City of Albuquerque Stormwater Construction Site Inspection Report

Project Name and Location	La Cuentista 2- DR Horton		
Site Contact Name & Agency	Brent Lesley- DRH Southwest Construction pblesley@drhorton.com	ESC File No. NPDES ID No.	D10E002B
Date of Inspection	11/06/18	Start/End Time	11:30am - 11:40am
COA Inspector Name	Curtis Cherne, Stormwater Quality		
Describe Present Phase of Construction	pads graded

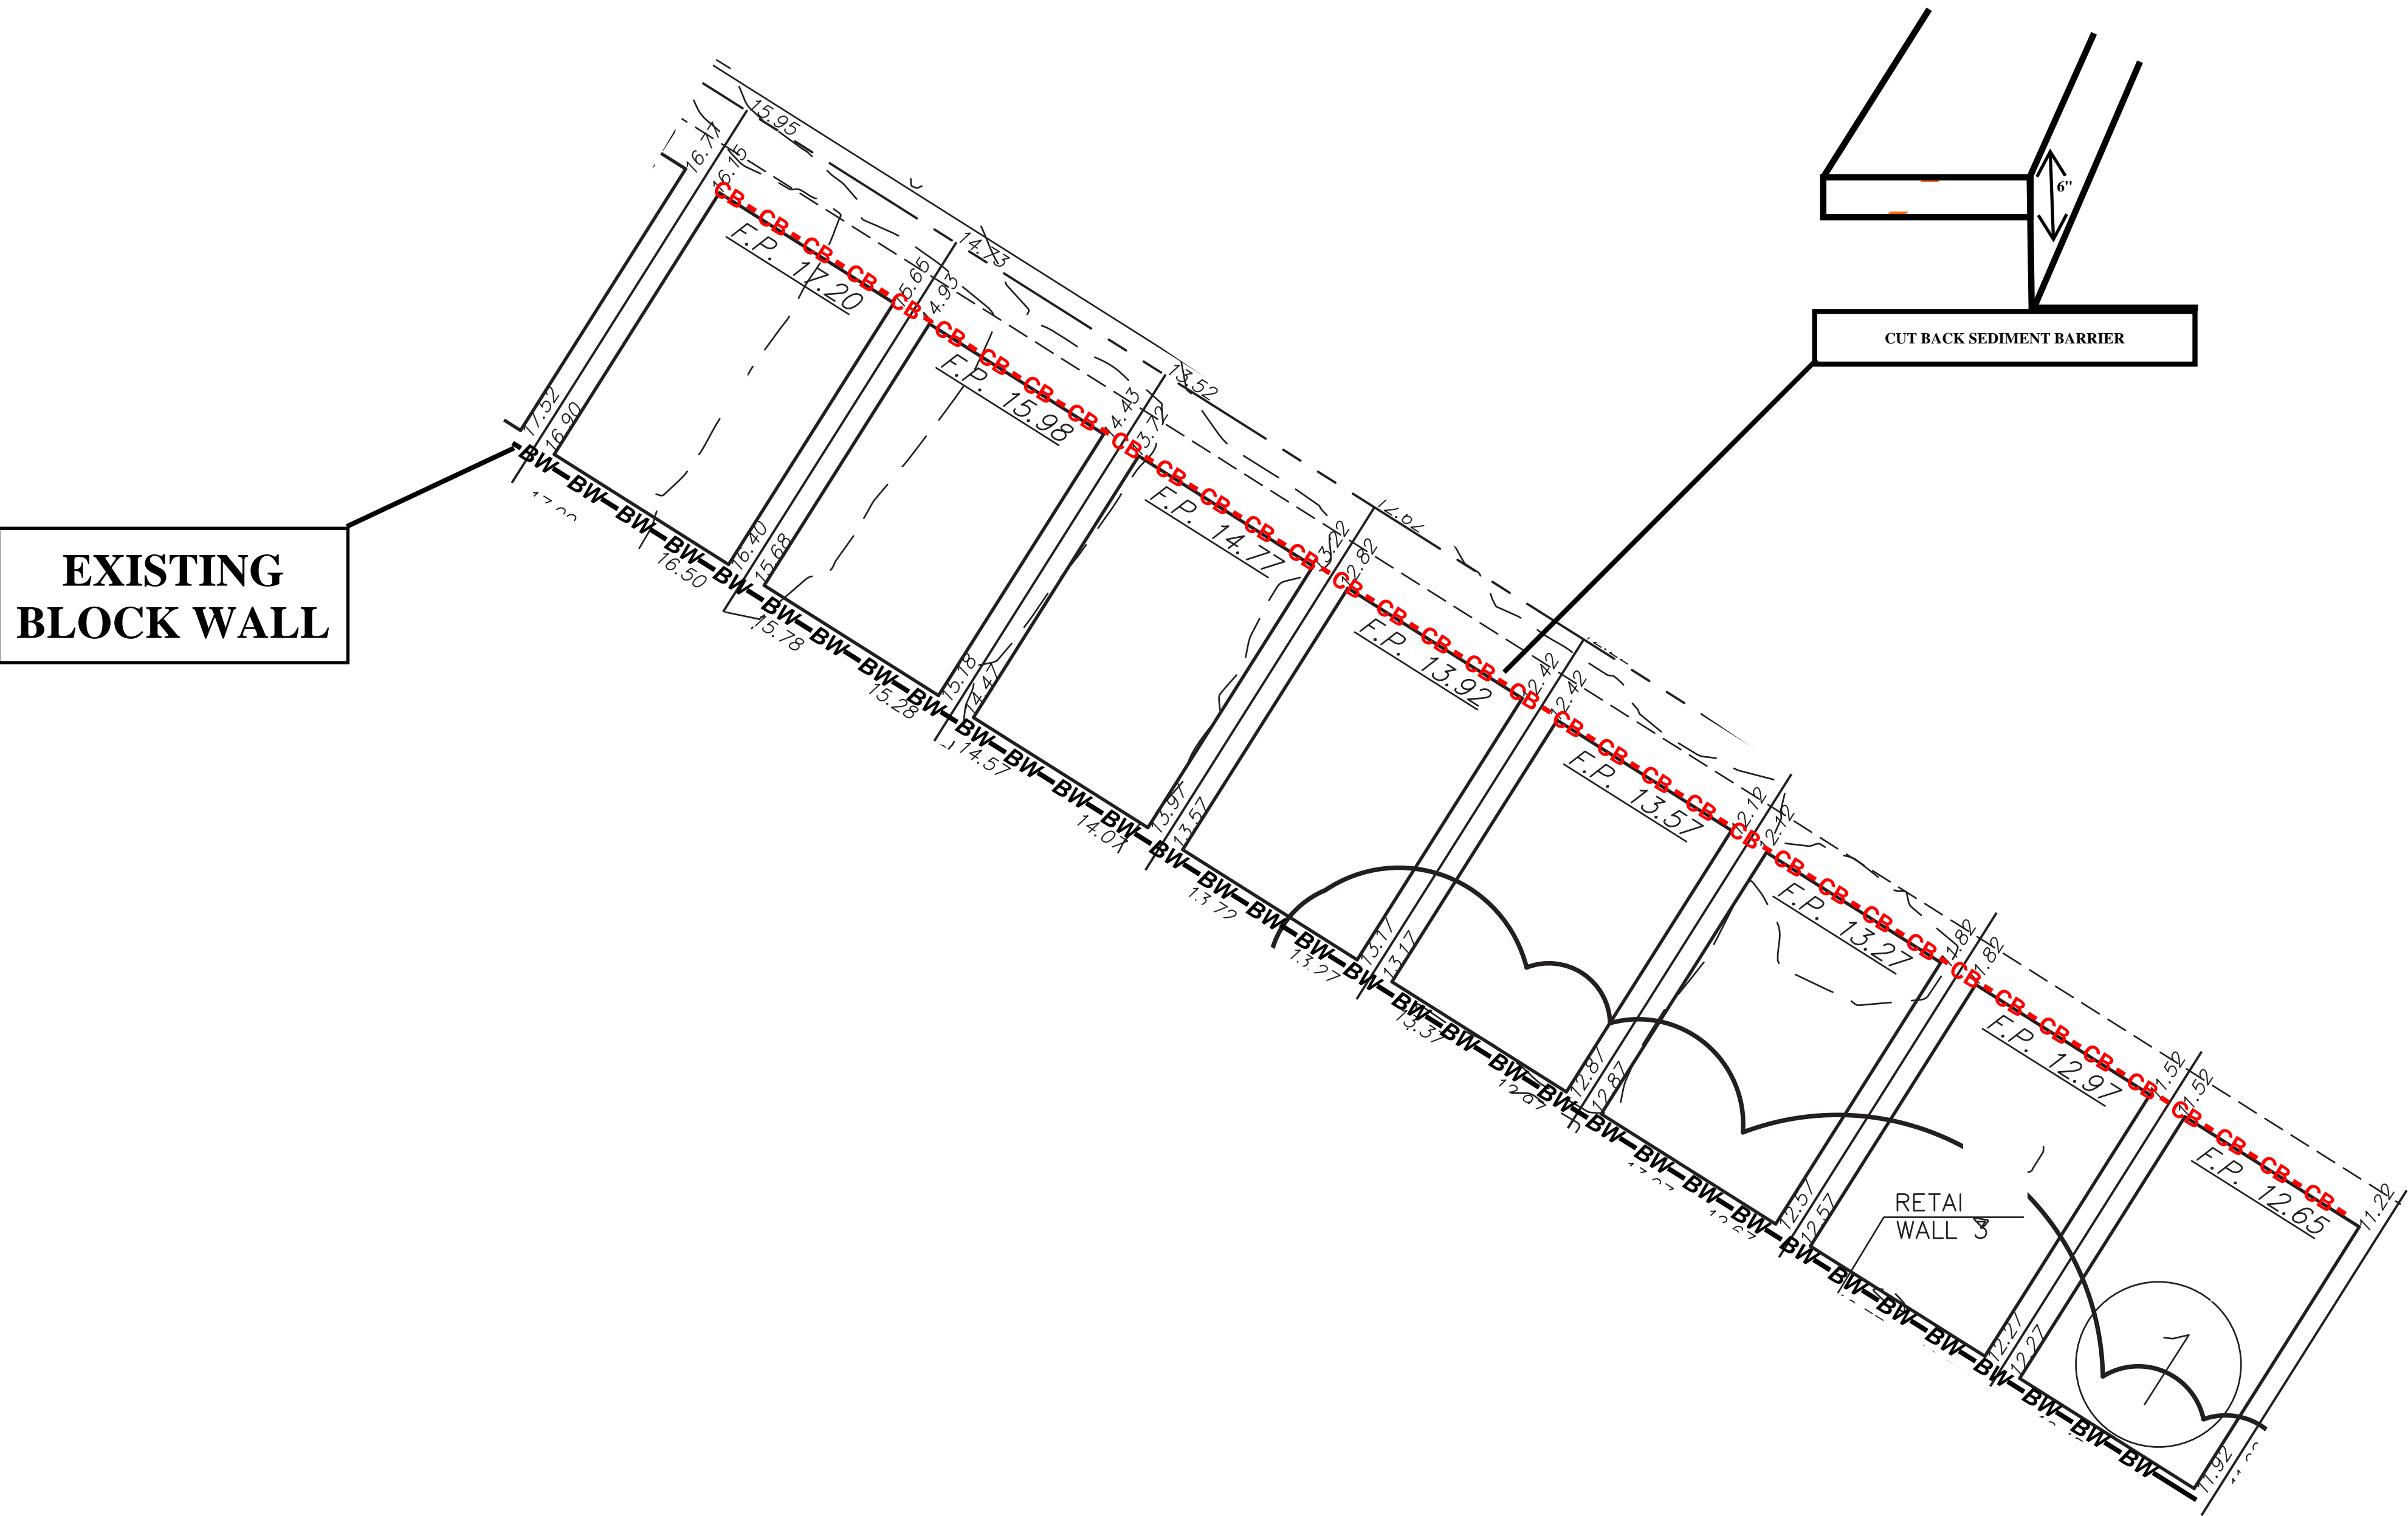
CGP	BMP / Activity	Maintenance Required? (1)	Corrective Action Required? (2)	Location and Notes
1.5	Post a Notice		X	Site Not Posted
2.2.1	Provide and maintain Natural buffer when Waters of the US < 50 ft			
2.2.3	Sediment control along any perimeter		X	Improve sediment BMP for lot 6301
2.2.3	Sediment control along any perimeter			
2.2.3	Sediment control along any perimeter			
2.2.3	Sediment control along any perimeter			
2.2.3	Sediment control along any perimeter			
2.2.3	Sediment control along any perimeter			
2.2.3	Sediment control along any perimeter			
2.2.4	Minimize sediment track-out			
2.2.5	Manage stockpiles		X	Manage Stockpile

Notes: Sediment controls must be installed on lots. Stockpiles must be managed, Site must be posted with NOI and Contact Information. Please complete within 7 days. Please provide self-inspection reports by end of day 11/07/18
